**Orica Southlands Warehouse Facility - MOD 5 (MP06_0191-Mod-5)
Request for Additional Information**

I refer to the report and accompanying documentation submitted with the modification application for the Orica Southlands Warehouse Facility (MP06_0191-Mod-5). After careful consideration, the Department is requesting additional information.

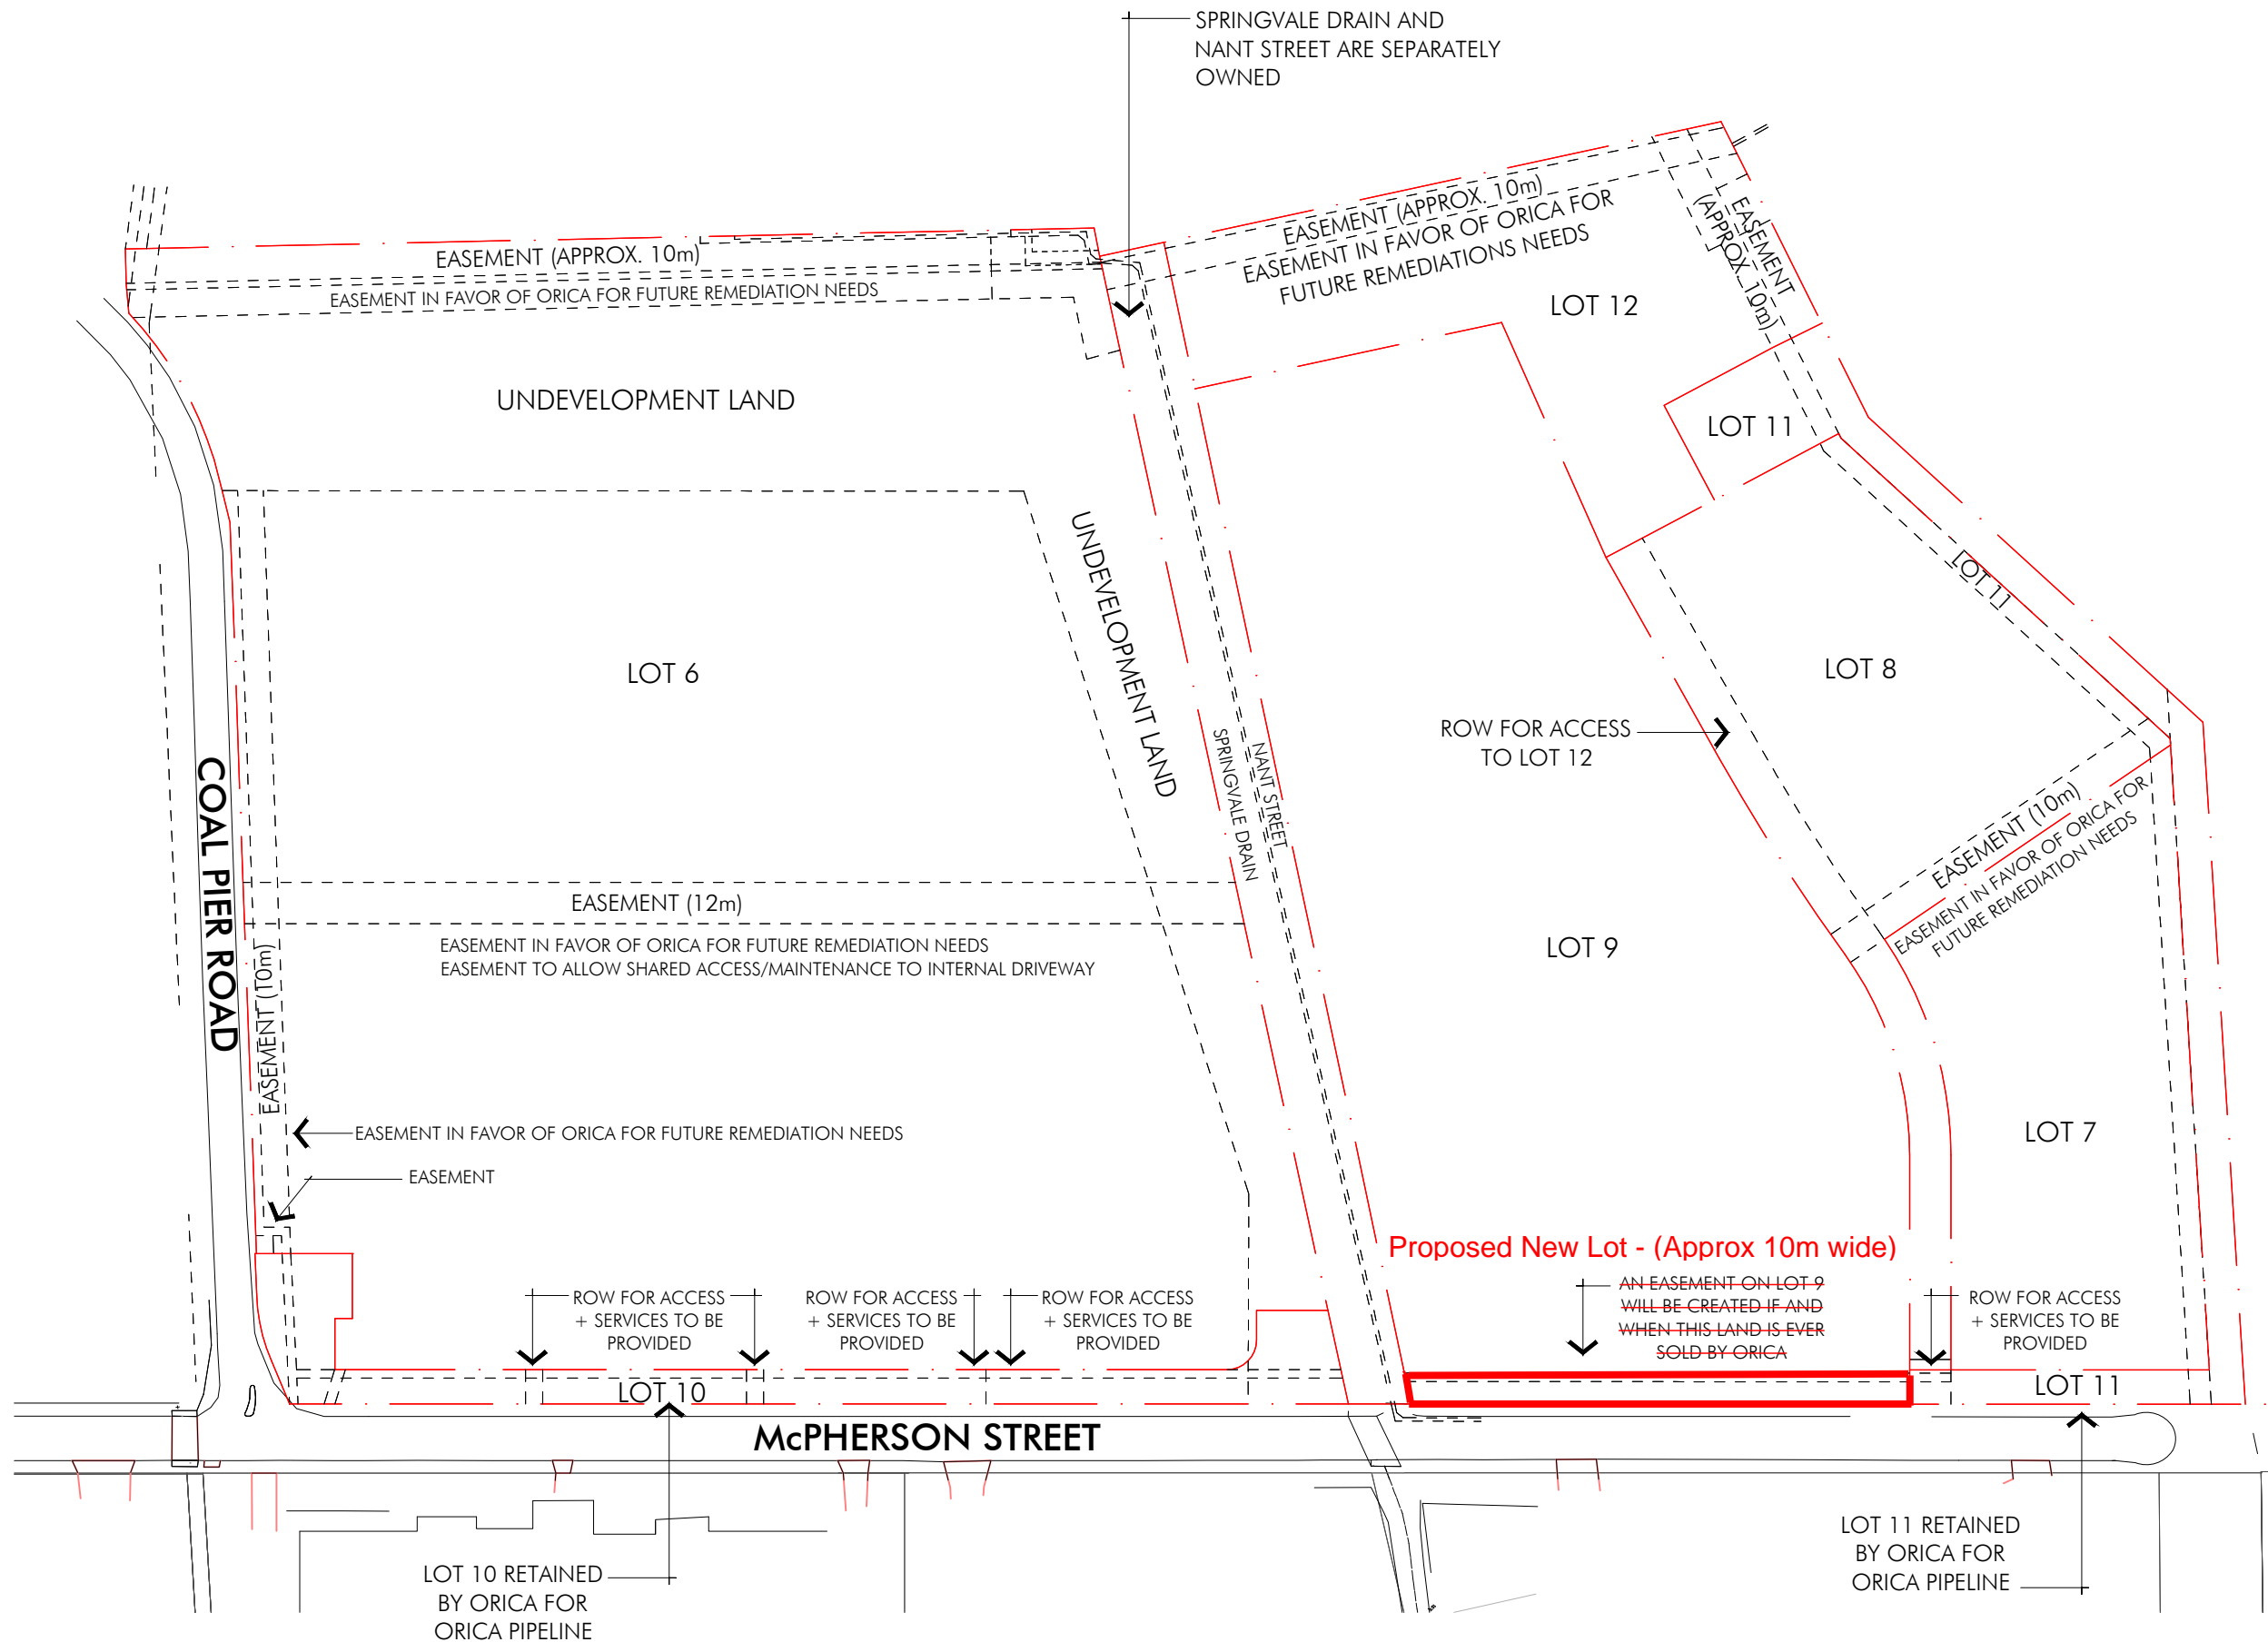
The Department notes that MP06_0191 has been previously modified on four occasions. The report and accompanying documentation submitted with MP06_0191-Mod-5 do not appear to be consistent with the most recently approved modification with regards to the subdivision layout. The Department requests additional information is provided to clarify the discrepancy.
